# Technical Memorandum

## Re: Site Plan Control Approval Application – 1463 Prince of Wales Drive – Traffic/Transportation Comments Response

This letter addresses the traffic and transportation related comments received from the City of Ottawa, dated July 22, 2017, for the 1463 Prince of Wales Drive Site Plan Control Application. Included within this submission was a Transportation Overview, dated February 2, 2017. No issues were noted with the current access configuration and continued use of this access arrangement in the future. It should also be noted that the Site Plan Control was submitted for an addition to the existing building for a total gross floor area of 527.8m<sup>2</sup>. This expansion constitutes a gymnasium and a single storey entry lobby with no additional rooms.

drawing title  
**SITE PLAN**

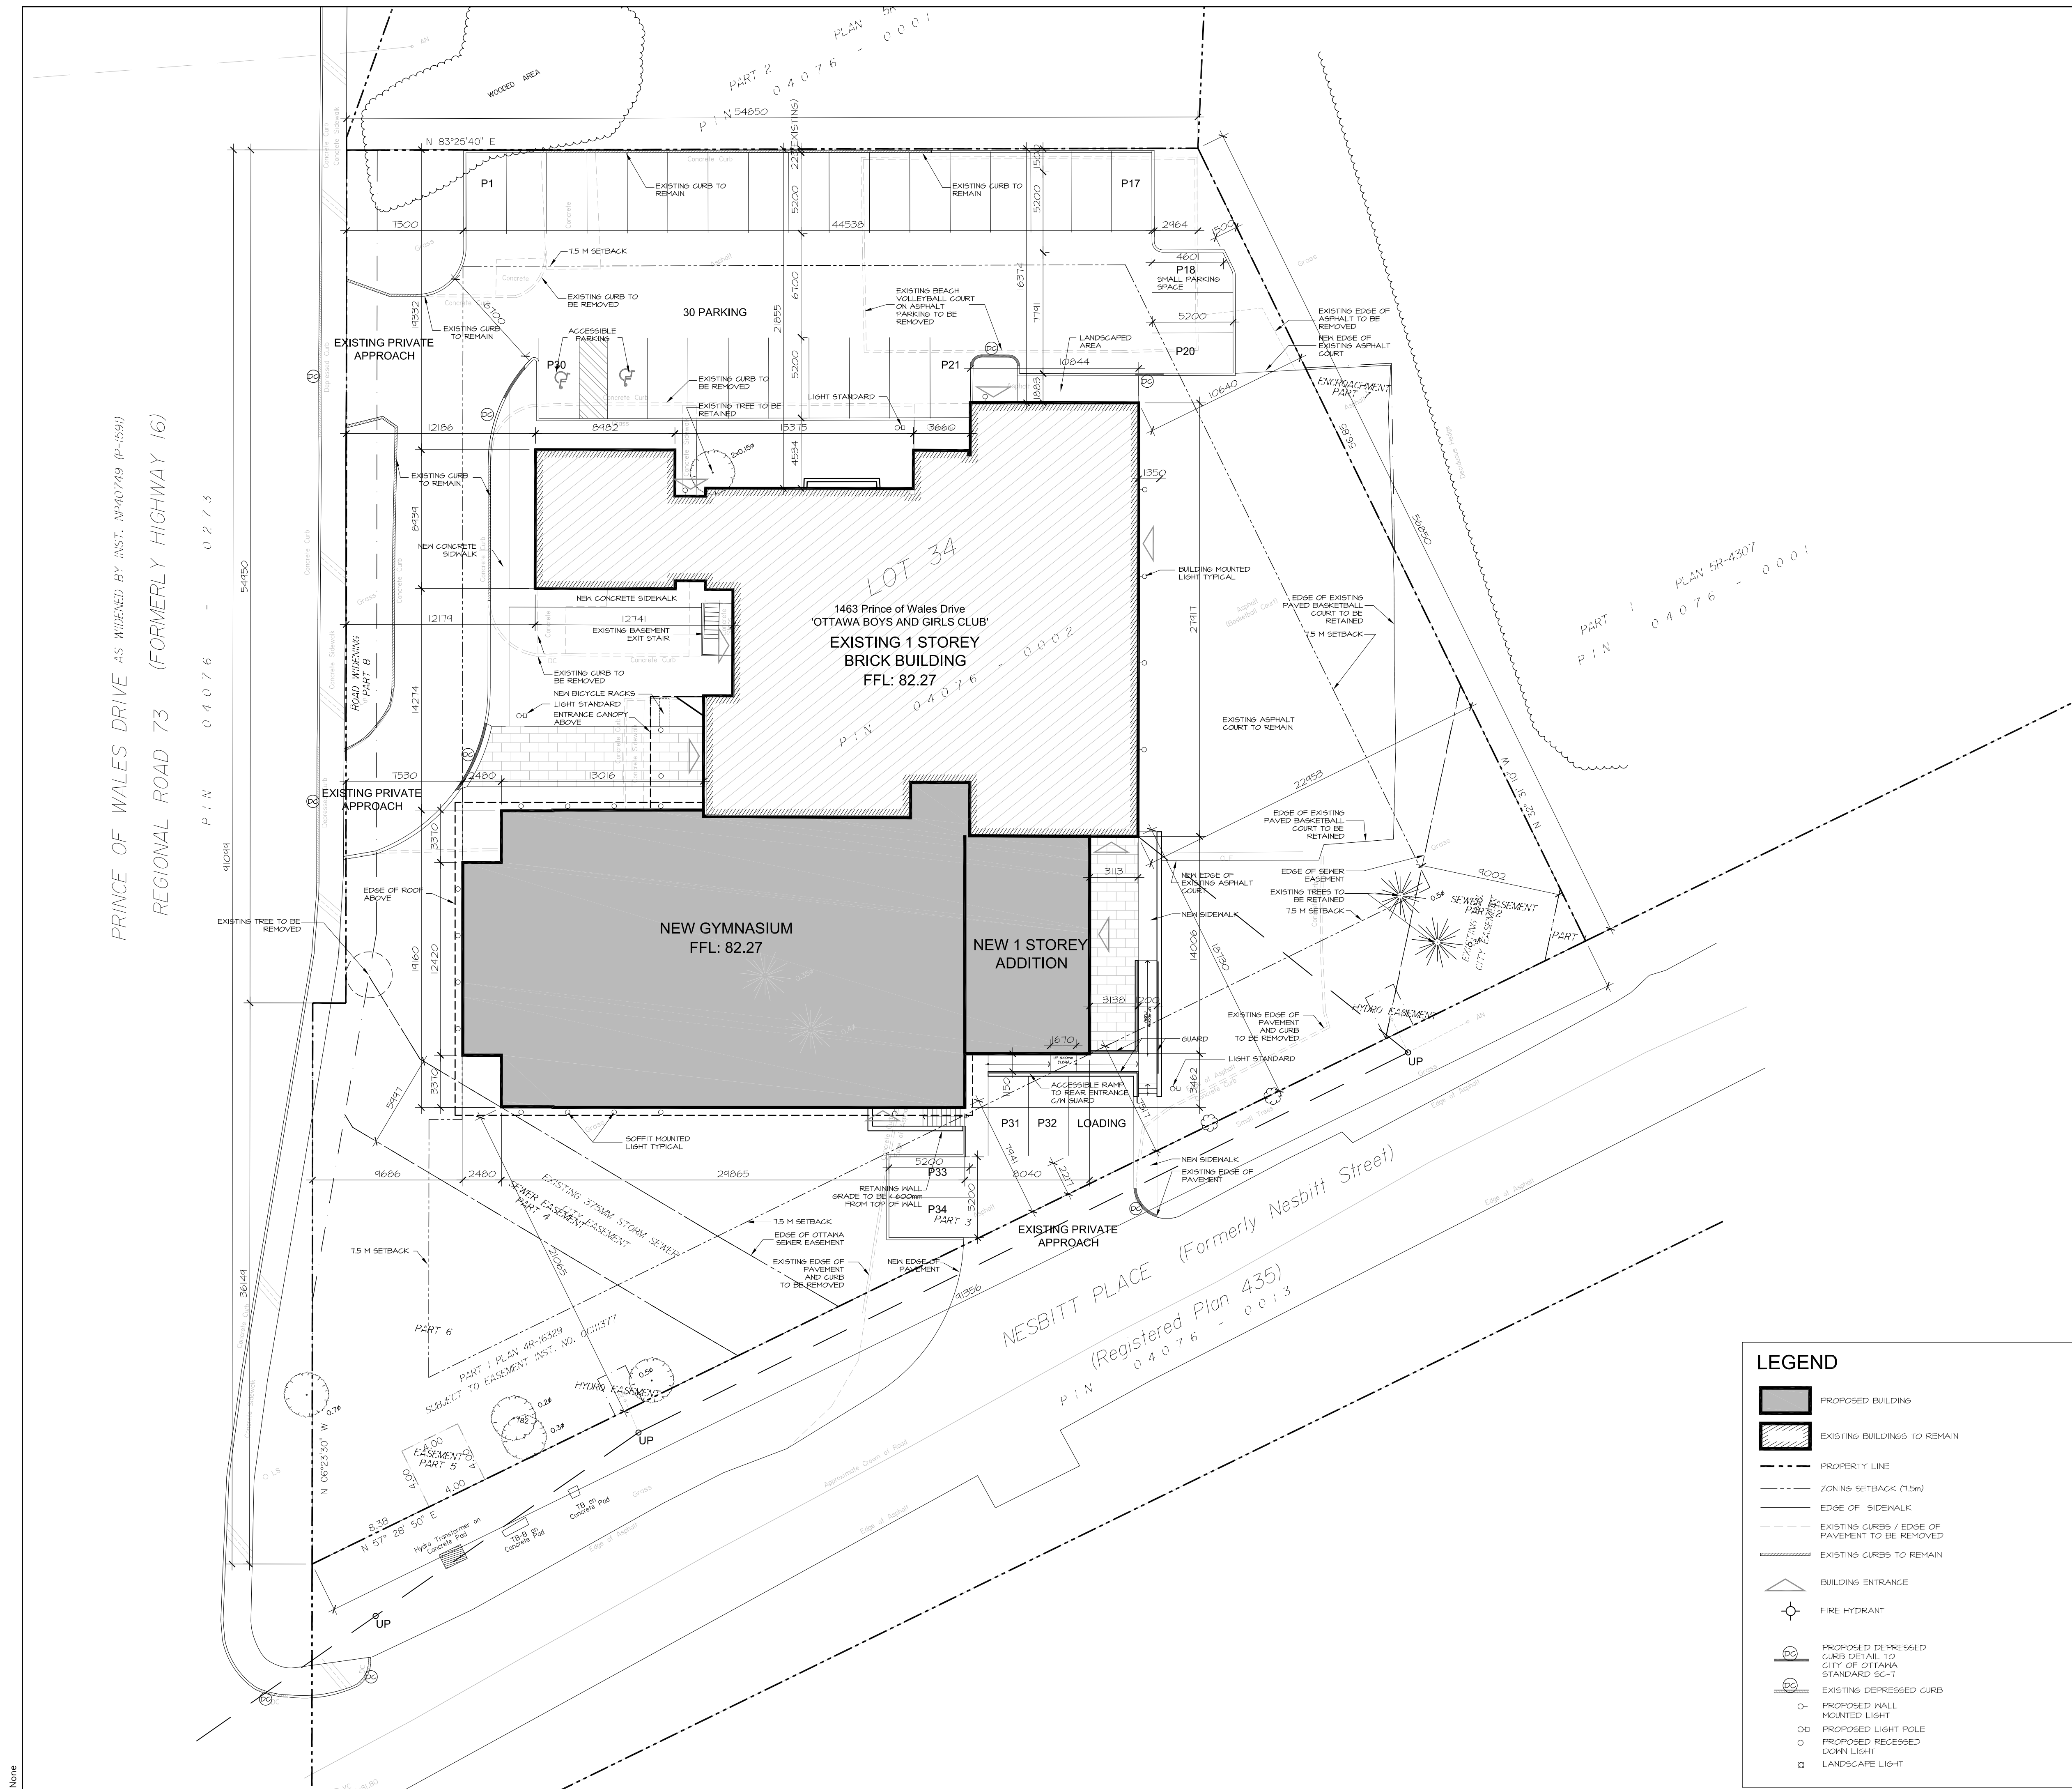
**Comment 27:** *The configuration of the parking lot off of Nesbitt Place is odd and it would appear that the vehicles would need to back out into the City's ROW to exit parking spots. This is especially an issue since on street parking is allowed on the north side of Nesbitt Place. Parsons report dated February 02, 2017 concluded that "the majority of vehicle traffic will use the Prince of Wales Drive connection once the Nesbitt Place connection is removed". The Site Plan doesn't match with the report, one or the other needs to be revised.*

**Response 27:** The current site plan was updated to provide a loading zone and four (4) parking stalls. While typically an issue on a traditional local road, Nesbitt Place has very low traffic volumes with only five private driveways along its length. As such, the reversing maneuver is not considered an issue for this location. The low vehicle volume, minimal speed, and available sight lines, due to the angle in which the stalls approach the roadway, the revised access/parking arrangement is not considered to be in conflict with the on-street parking. An alternative approach would be the reduction of the parking requirements for the site, as the current parking lot is currently underutilized during normal Boys & Girls Club operations.

**Comment 25:** *The minimum clear throat length required is 15.0 metres from end of curb radius. Please refer to TAC Manual Part 2; Table 3.2.9.3 and Figure 3.2.5.2 for appropriate throat length and dimensioning.*

**Response 25:** As the existing building and driveway connections to Prince of Wales Drive are not being modified, extending the existing throat length is not considered to be within the scope of the submission. In addition, the TAC Guidelines (2017 update Book 8, Section 8.9) provide minimum throat lengths for major driveways only. As the driveways to Prince of Wales Drive are not considered 'major driveways', the existing throat lengths are considered acceptable.
